**Consultation Response from KC,
Highways Development Management**

2022/91793 31, Crimble Bank, Slaithwaite, Huddersfield, HD7 5EU

Erection of single and two storey rear extension and exterior alterations

Date Responded: 01/07/22

drawing no.: rev:
2208 - XPP - 01 A

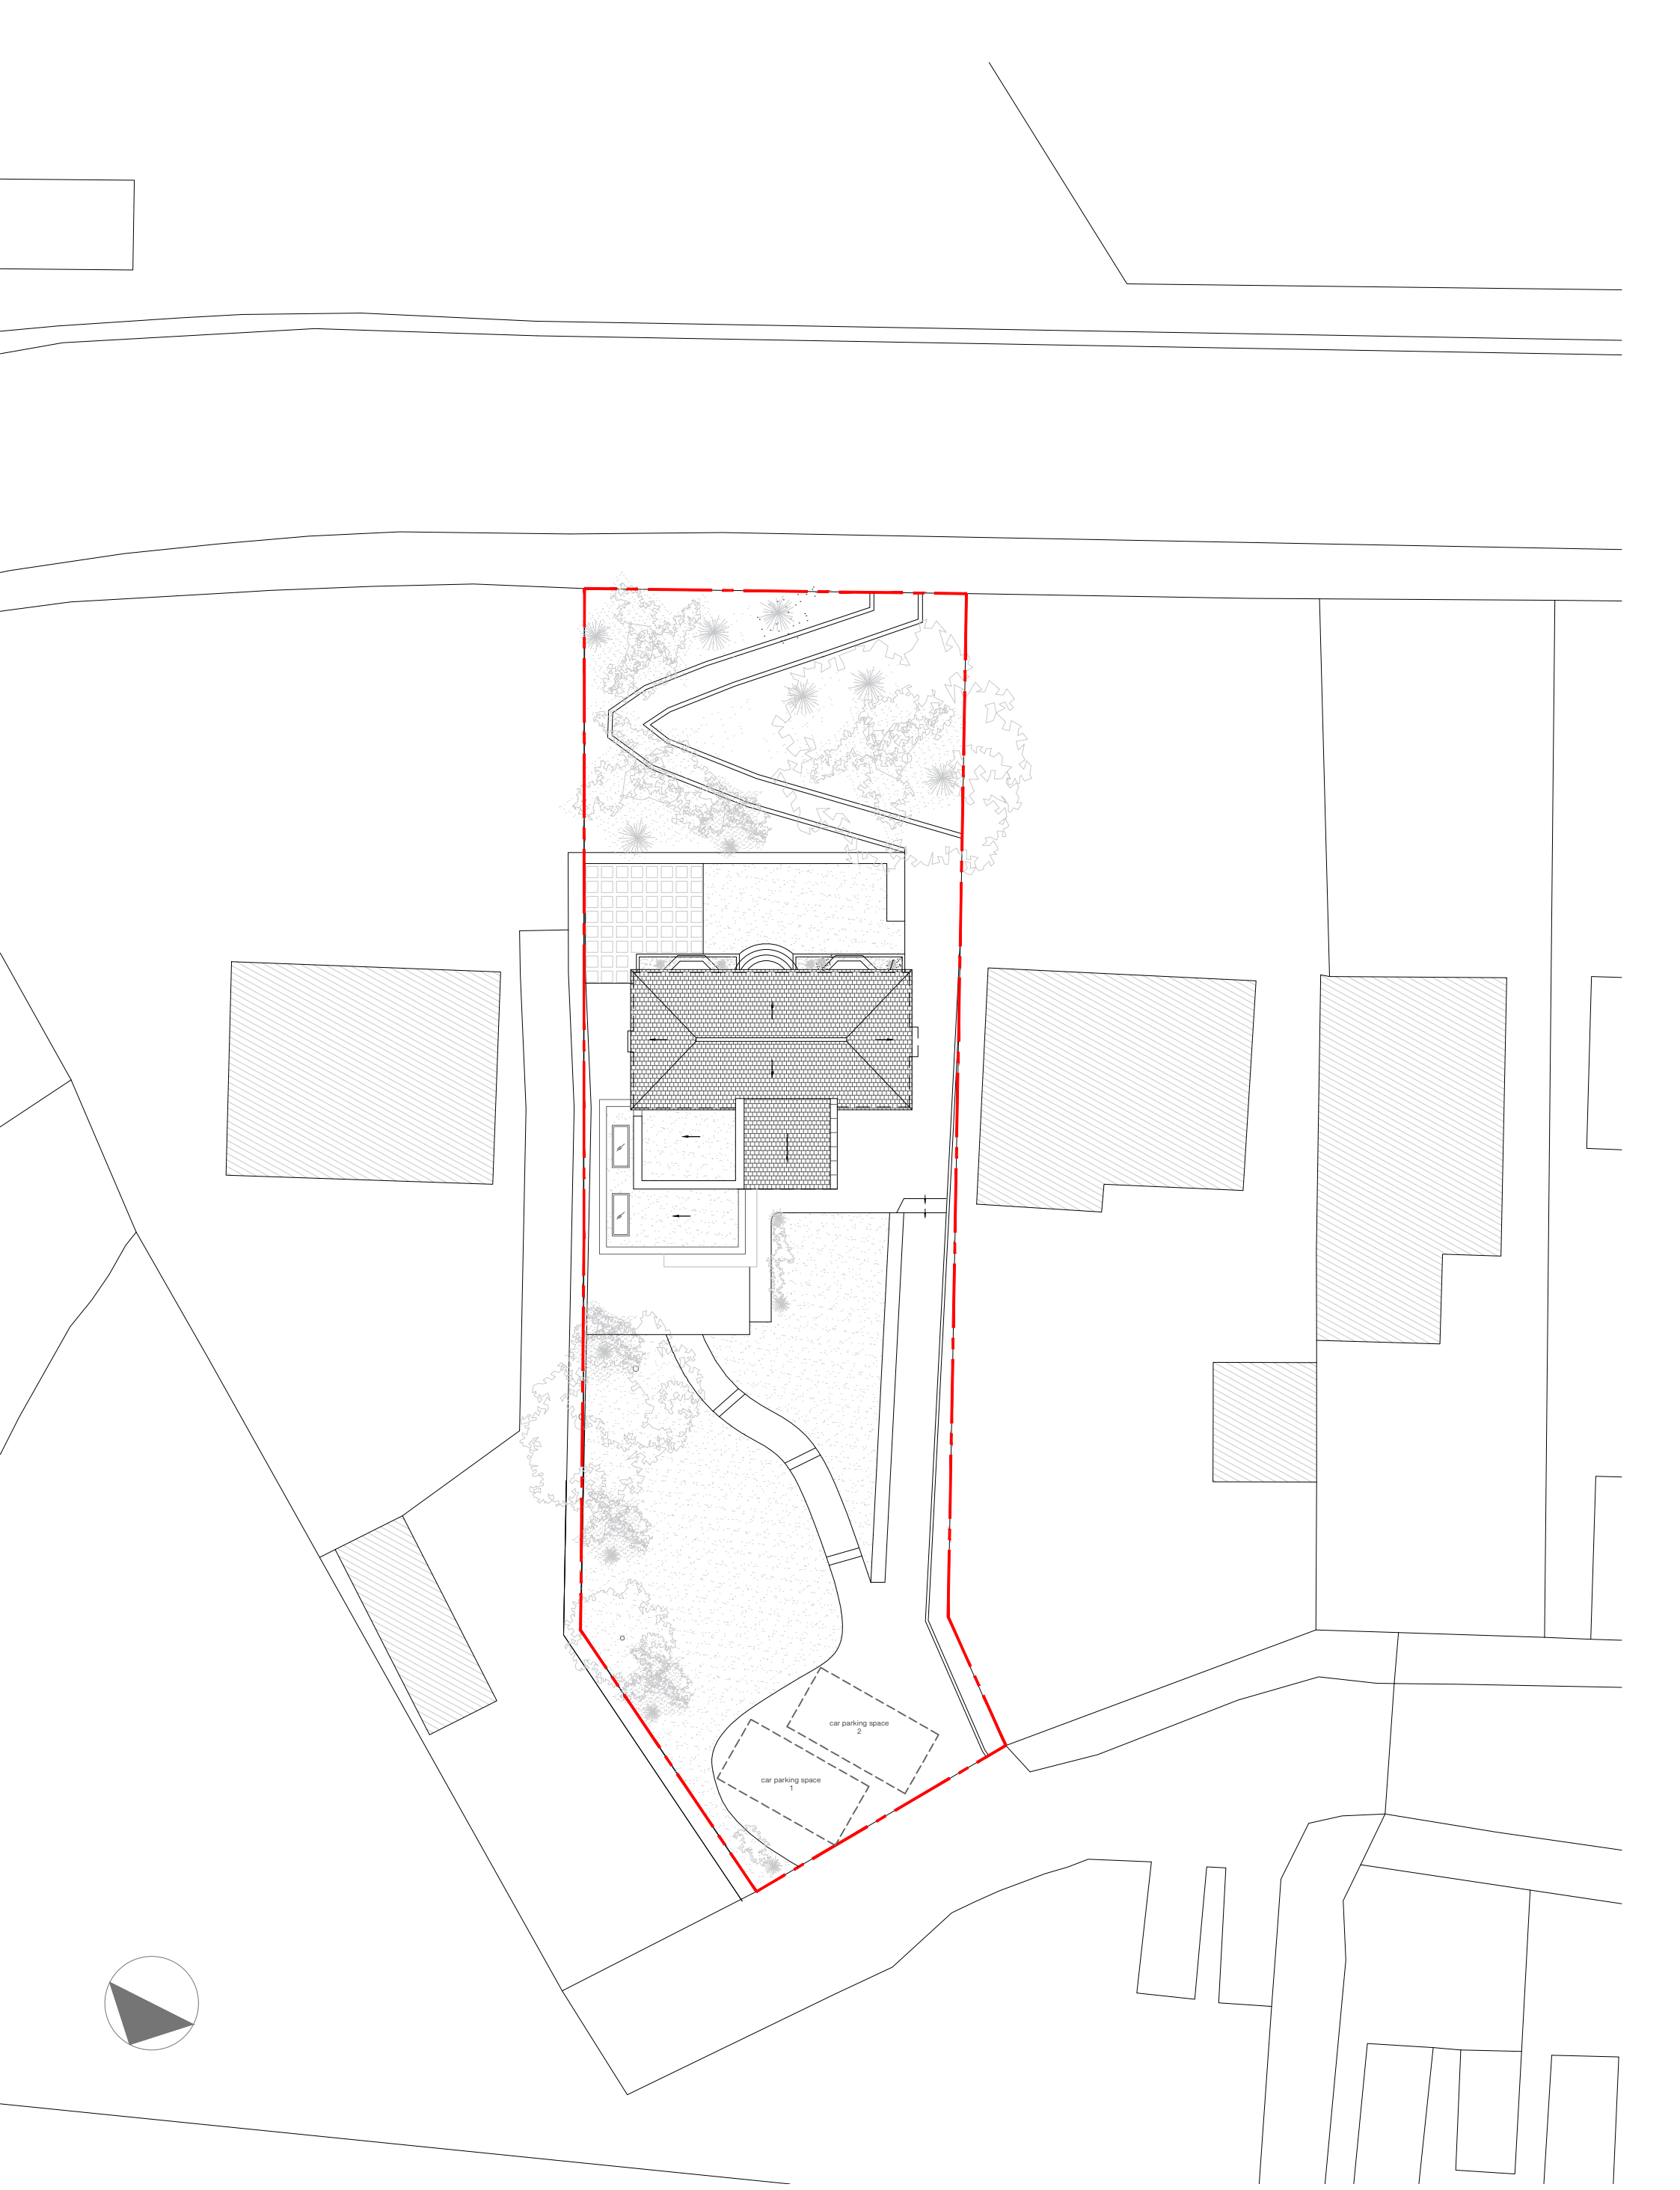
The proposal would significantly increase the size of the existing dwelling to create a four-bedroomed property. The existing dwelling does not benefit from any off-street parking and there is no intention to provide any as part of this application.

There appears to be sufficient room to provide a driveway off Olney Street, and Highways DM would ask for this to be added to the scheme. Kirklees' Highway Design Guide SPD recommends that a dwelling of four or more bedrooms should have three off-street parking places.

- An amended scheme with off-street parking provided for the dwelling.
